PLANNING REF: A/64/21/PL - Former Shrublands Nursery, Roundstone Lane, Angmering BN16 4AT

Consultation response – Housing Strategy and Enabling Manager Arun District Council

Use and Amount Plan

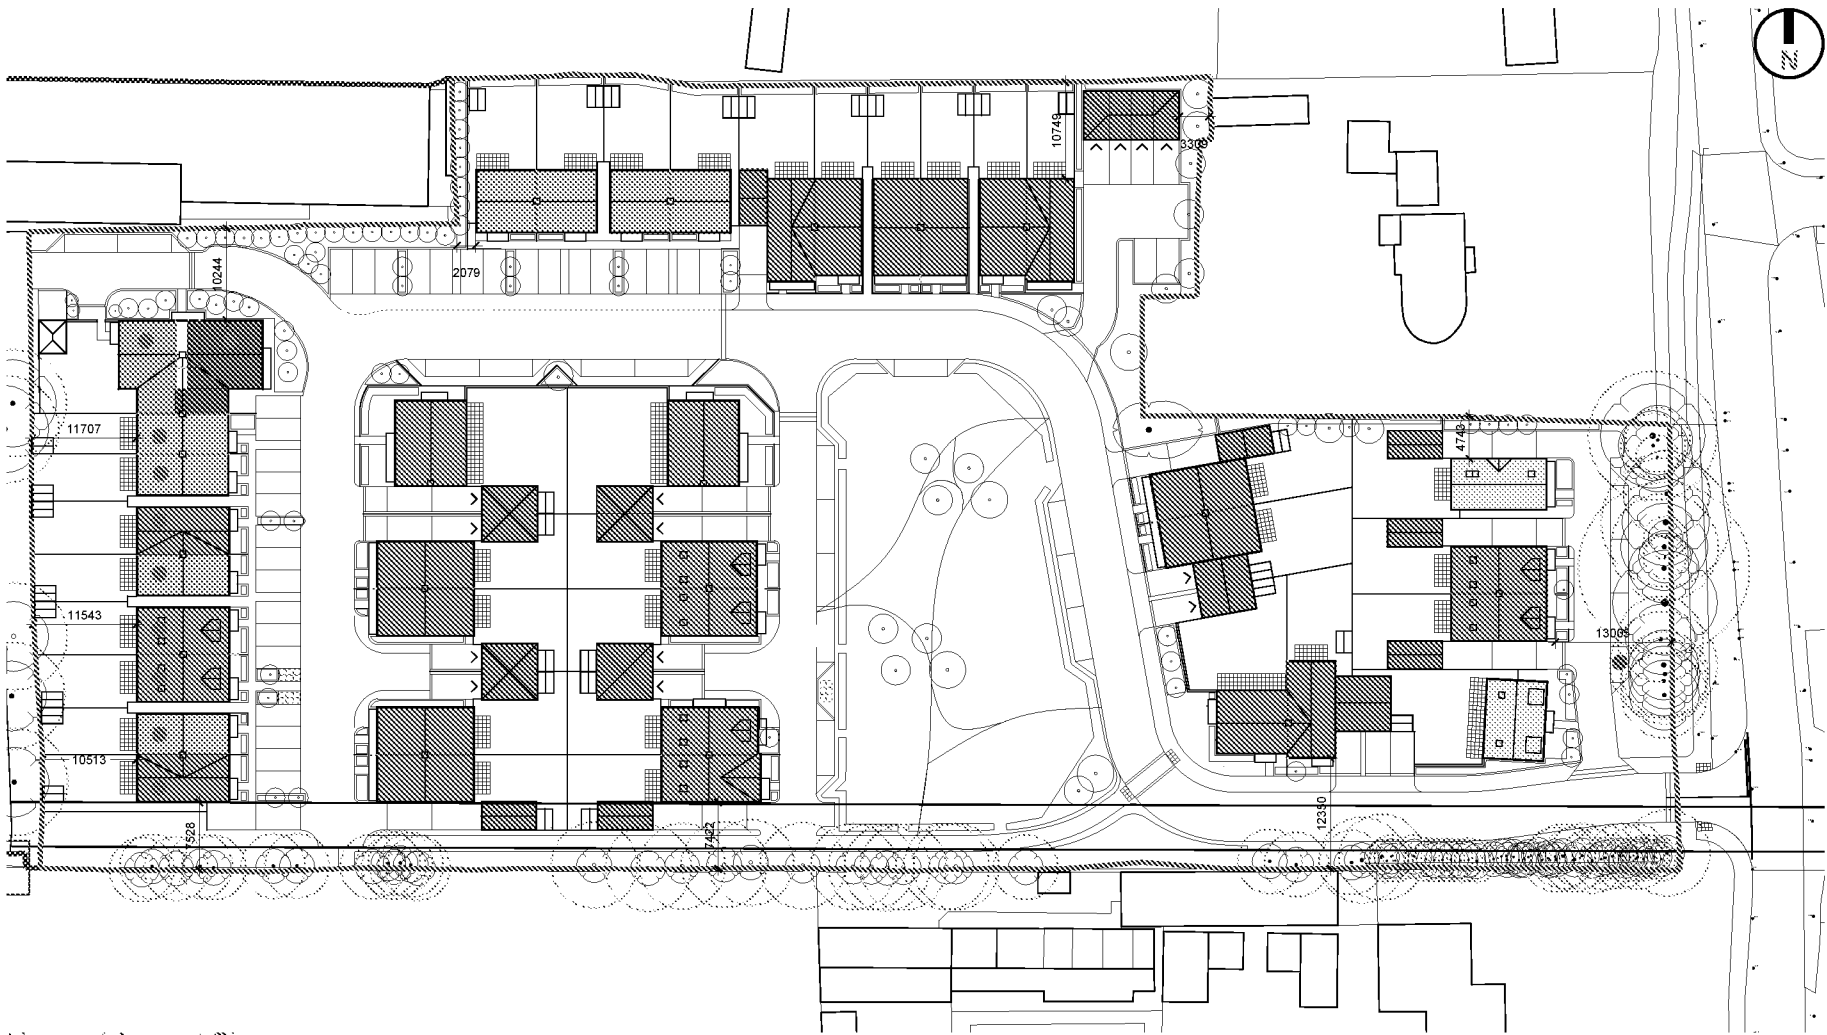
We feel that the Affordable Housing Plan as presented contains too many larger units so we would like to see this amended to replace the 4 bed units with 2 bed units as follows:

We object to the location of the affordable housing as currently presented, as the affordable housing should be located in small clusters across the site and not all in one part of the site as proposed.
